**Housing Strategy & Development Team  
Housing Service**

Planning Application Comments

**Planning Application Number:** 23/01633/F

**Site Name:** Calthorpe Street and Marlborough Road, Banbury

Drawing file: 20176-0352-P-00 Town House East Elevation.pdf

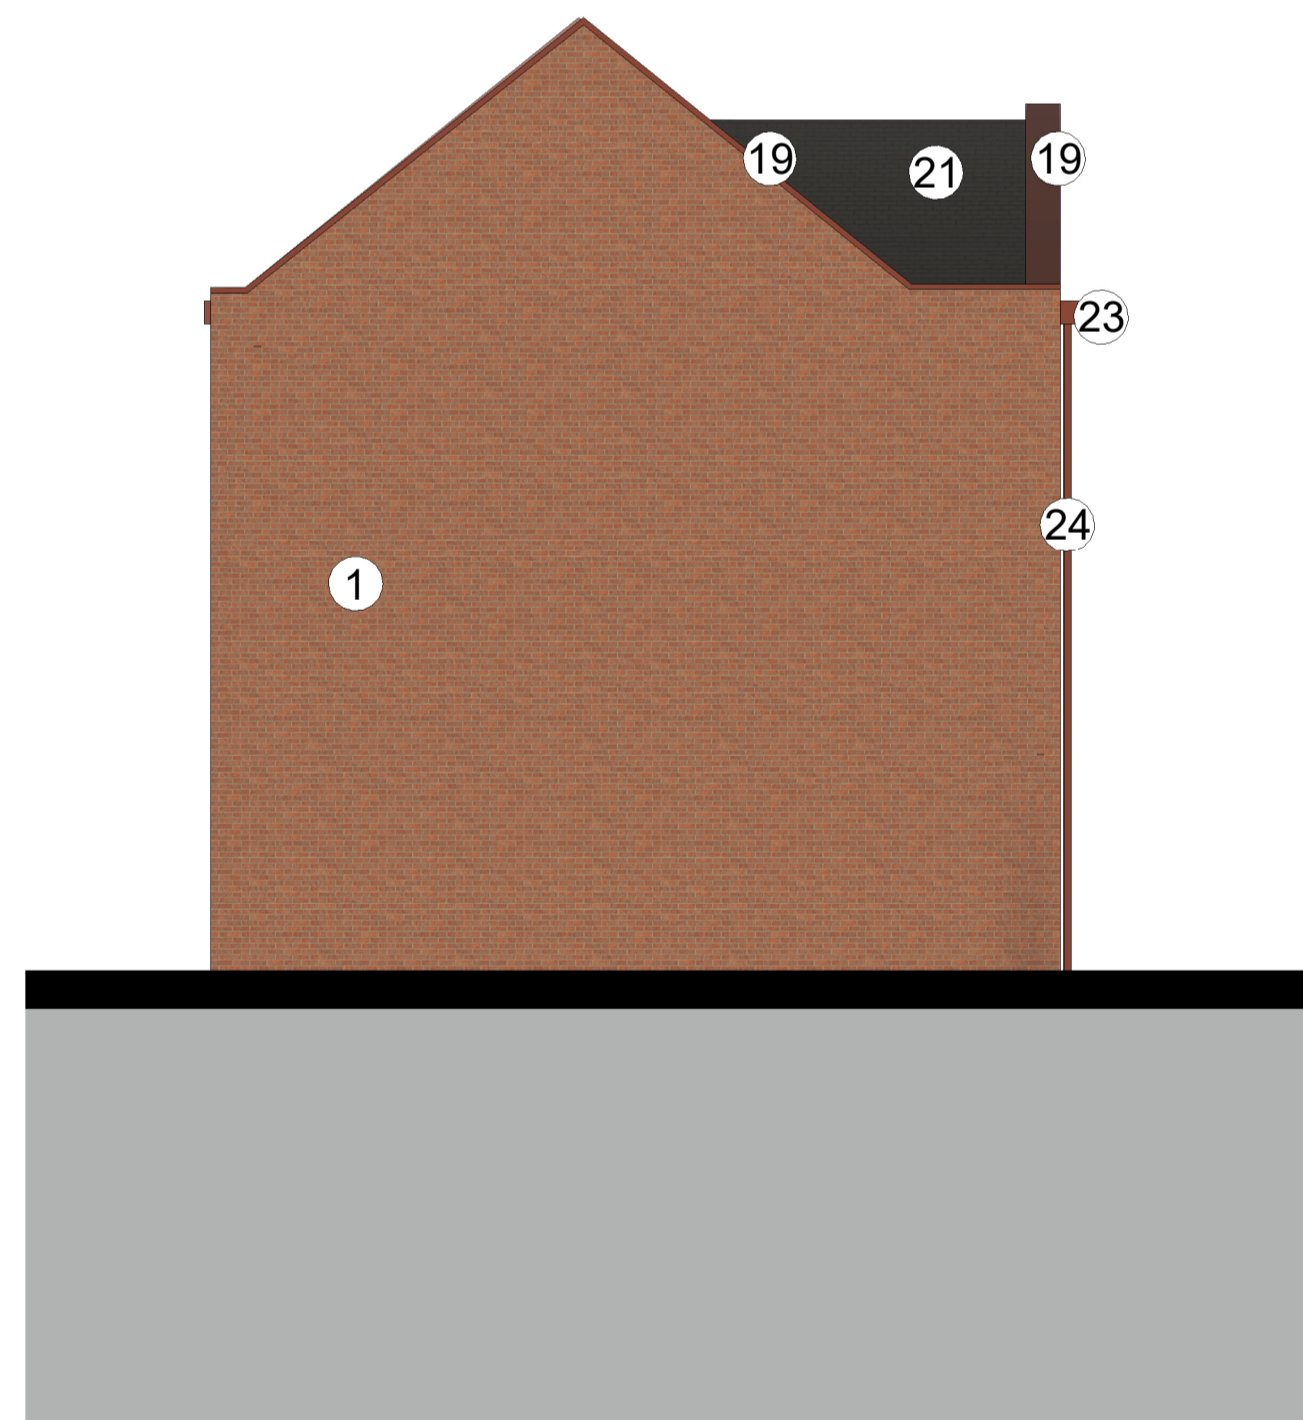
<p><b>Size standards</b></p>	<p>The Developer Contributions SPD sets out CDC's expectation that all affordable housing provided under a rented tenure will be built to the Nationally Described Space Standards. We request that any plans or Affordable Housing Schemes clearly state the dimensions and the person occupancy as well as number of bedrooms. We need to ensure that the rented dwellings comply with NDSS dimensions for the exact size (1-bed 2-person etc).</p> <p>Intermediate housing should be built to the same or better space standards including garden sizes as the equivalent market housing on the site.</p> <p>The size of the 4 bedroom town houses is unclear. They</p>

<p>appear to be designed as 7 or 8 person homes. They must meet NDSS and be at least 7 person units. The size and floor plans would need to be agreed in further detail.</p> <p>Furthermore it appears that some of the affordable units proposed may not meet NDSS including:</p> <ul style="list-style-type: none"> <li>• 1B1P flats shown as 38m<sup>2</sup></li> <li>• 1B2P Duplex's shown as 30m<sup>2</sup></li> <li>• 3B6P Duplex's shown as 50m<sup>2</sup></li> <li>• 2B4P Duplex's shown as 50m<sup>2</sup></li> </ul> <p>All affordable units must meet NDSS and plans must be altered to achieve this where this is not the case.</p>
<p><b>Layout, external appearance and tenure distribution</b></p>	<p>The Developer Contributions SPD sets out CDC's expectation that where appropriate, affordable housing should not be clustered in any more than 10 units of one tenure and 15 units of multiple affordable tenures with no contiguous boundary of the clusters.</p> <p>There can be flexibility in some circumstances, however we expect the above to be adhered to so that the tenures are distributed, and the scheme is "tenure blind". This is also achieved by the use of the same external materials, attention to the layout e.g. landscaping, parking arrangements and equal access to play areas.</p> <p>On this proposal it is noted that all affordable housing is clustered in blocks F and G. Whilst these are listed as separate blocks they appear to be clustered together as one block which all overlook the same small inner courtyard area.</p> <p>We understand some of the reasoning that clustering together can have benefits for maintenance by the RP, however, we require the applicant to obtain feedback from RPs specifically on this point to confirm their views and preferences.</p> <p>In any case, the current clustering of the affordable units is not acceptable. In particular 46 units in block F is too high a density of affordable units. Particularly when these are suggested to be 1 and 2 bedroom rented units. The addition of block G which appears to be attached to/in the same area as block F further makes the clustering unacceptable.</p> <p>Affordable units must be distributed more evenly across this site and the proposals must have regard to the requirements set out in our SPD setting out our expectation that affordable housing should not be clustered in any</p>

Drawing file: 20176-0203-P-00 Block A-B First Floor Plan.pdf

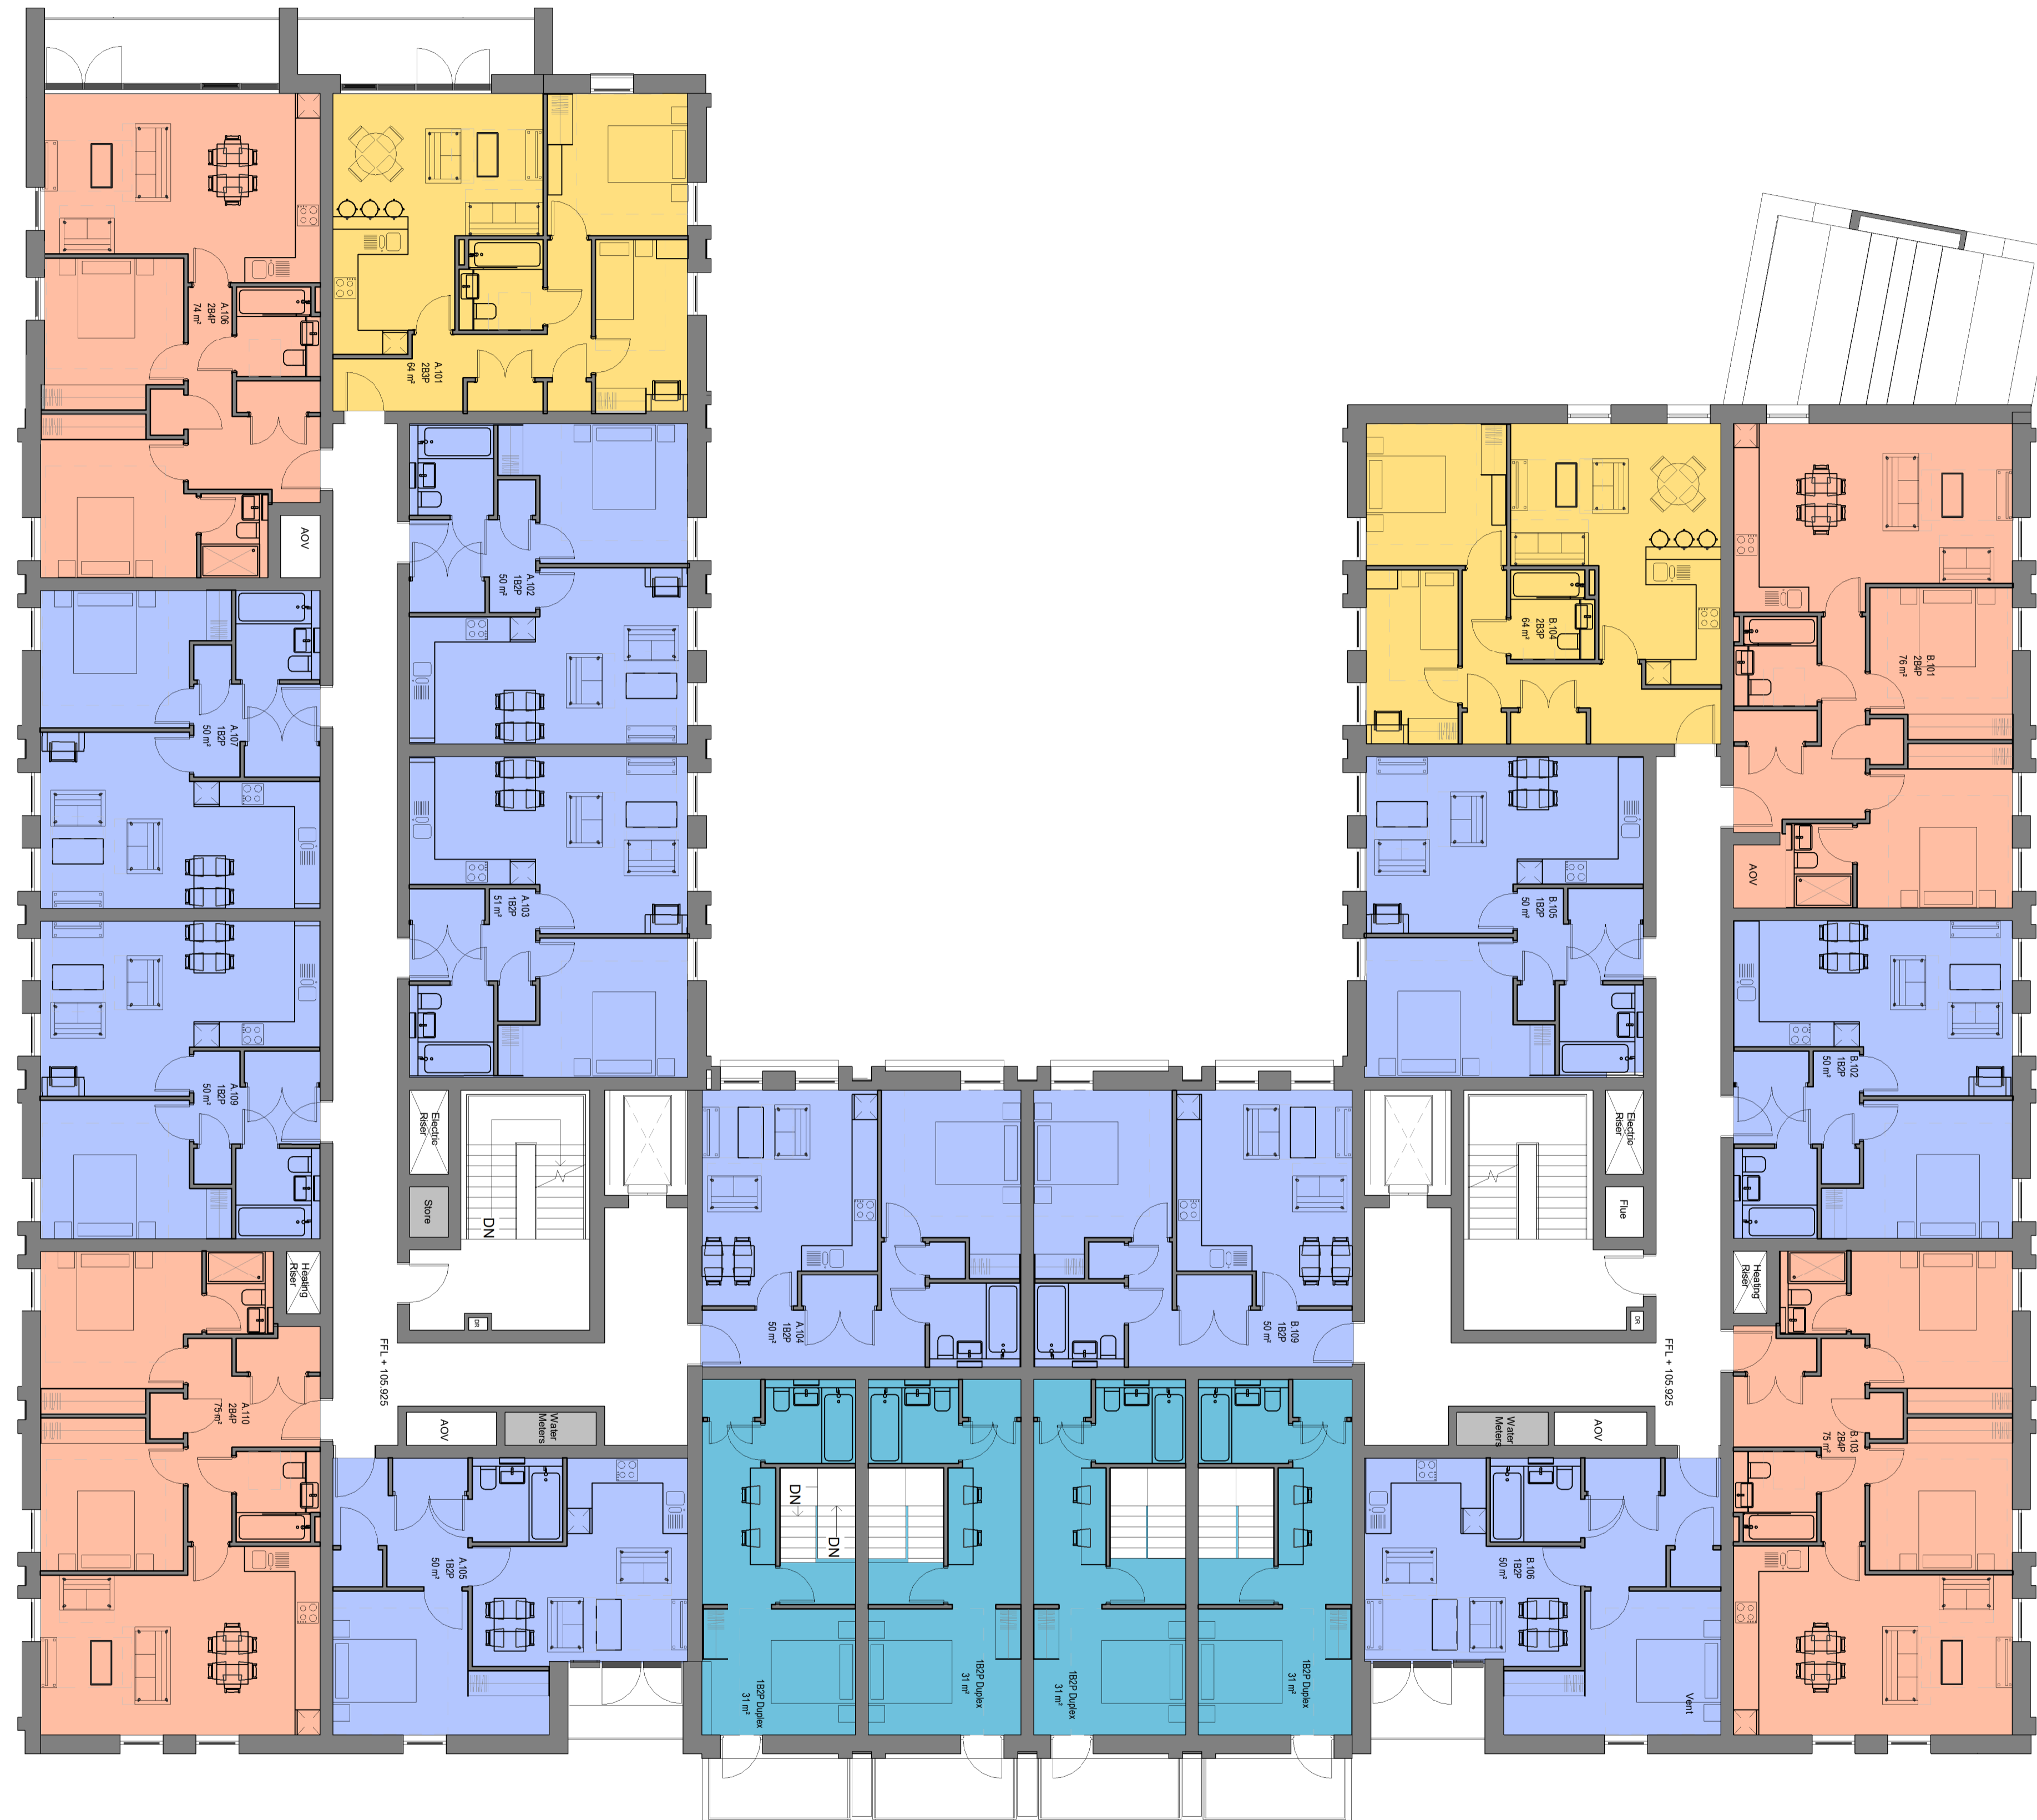
<p>There still remains an oversupply of 1-bedroom units at the expense of larger units and the 2-bedroom and 3-bedroom units are unsuitable for families as they contain little/no private outdoor space.</p>
<p><b>Accessible &amp; adapted provision</b></p>	<p>The Developer Contributions SPD sets out CDC's expectation that 50% of the affordable rented housing required will be built to Building Regulations Requirements M4(2) Category 2: accessible and adaptable dwellings.</p> <p>We expect that any ground level dwellings are included in the 50% and that Level Access Showers and level access thresholds are installed from the outset.</p> <p>It is unclear what percentage of the affordable units will meet M4(2) and plans appear to show baths provided on ground floor homes rather than any level access showers.</p> <p>In addition, 1% of the affordable housing should be built to Building Regulation Requirement M4(3) Category 3: Wheelchair User Dwellings. Where 1% equates to less than one dwelling, we would request that at least one wheelchair adapted dwelling is provided as there is a pressing need for this provision in a range of property types and sizes.</p> <p>This requirement is expected to be assessed on a site-by-site basis in discussion with the developer, and we would welcome discussions with the applicant regarding the provision of wheelchair adapted properties ie Category 3 2(b).</p> <p>It is unclear how many units are proposed to be M4(3)(2b) and if the type, size and floor plans of these units are acceptable.</p>
